Application for a non-material amendment following a grant of planning permission.

Erection of detached bungalow - plot 1 (Outline approval H16-1000-16).	
Reference number:	H16-0266-19
Date of decision	18/06/2019

Window / door amended positions and sizes

Elevation 01 – Front
1 : 100

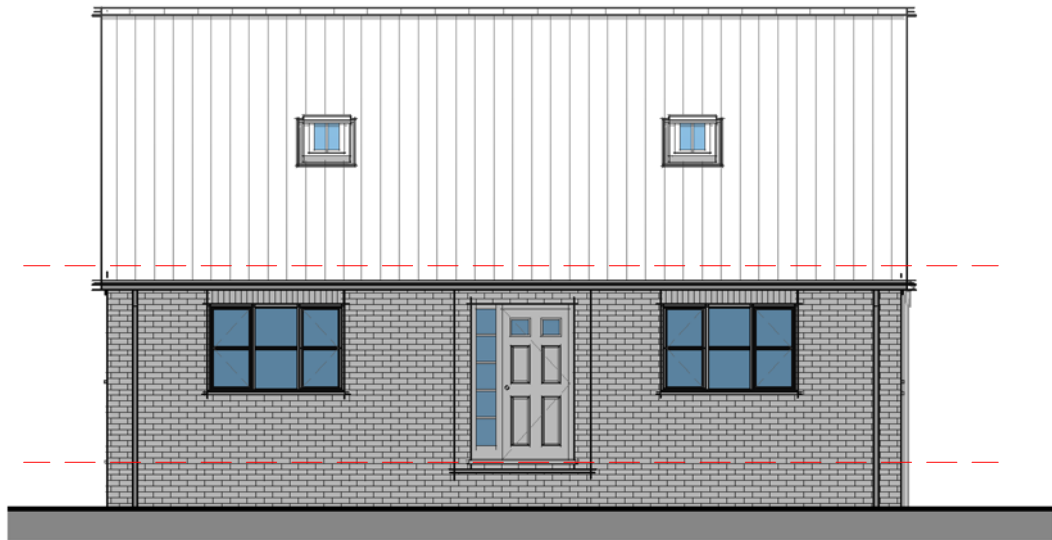
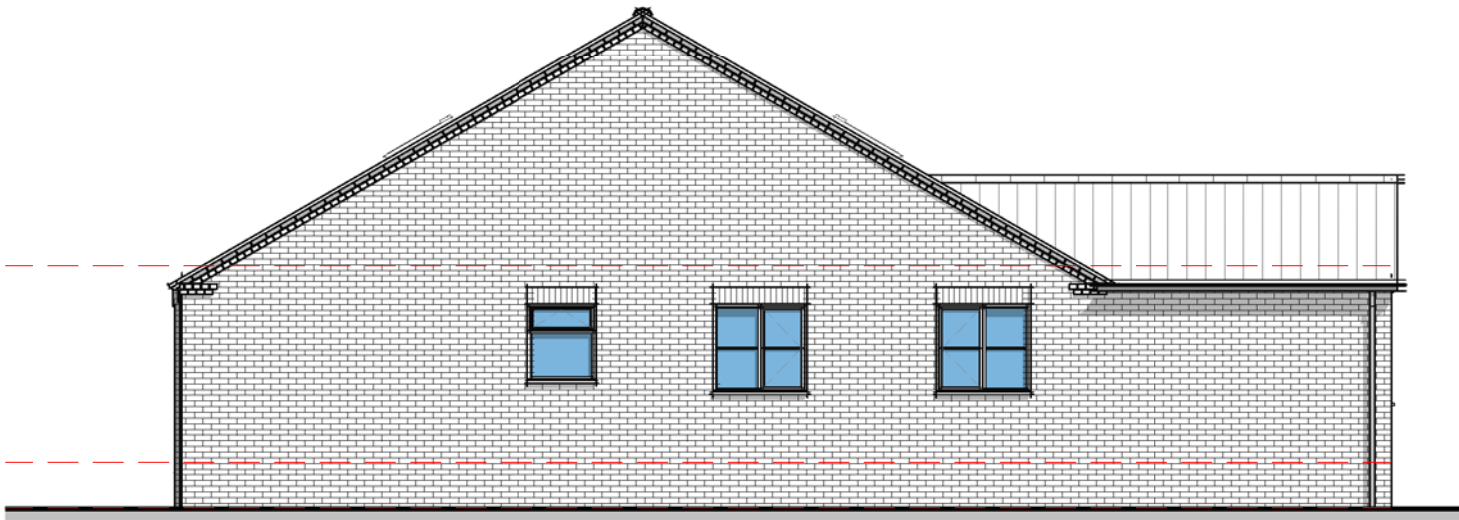
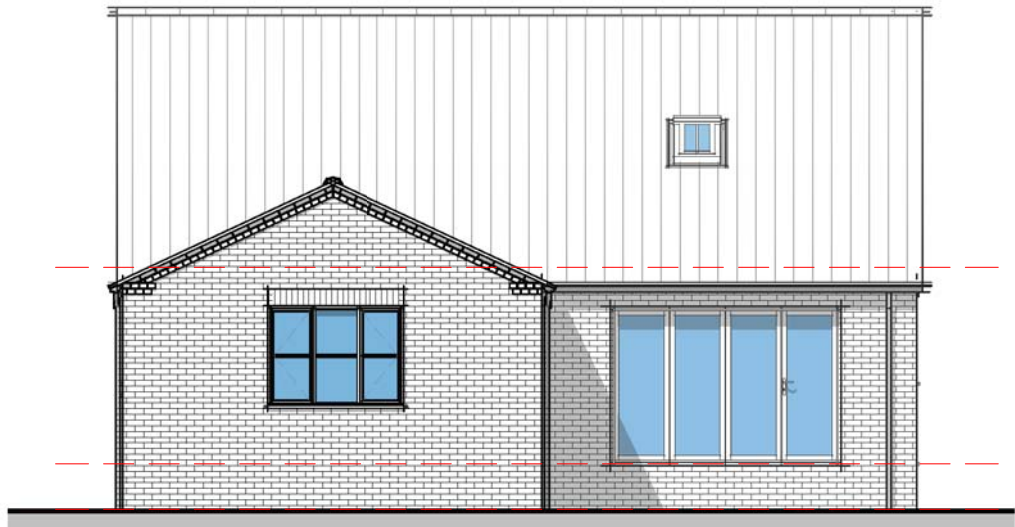
3036 - 02 Proposed Elevations
3036 - 03 PLOT 1 Floor Layout
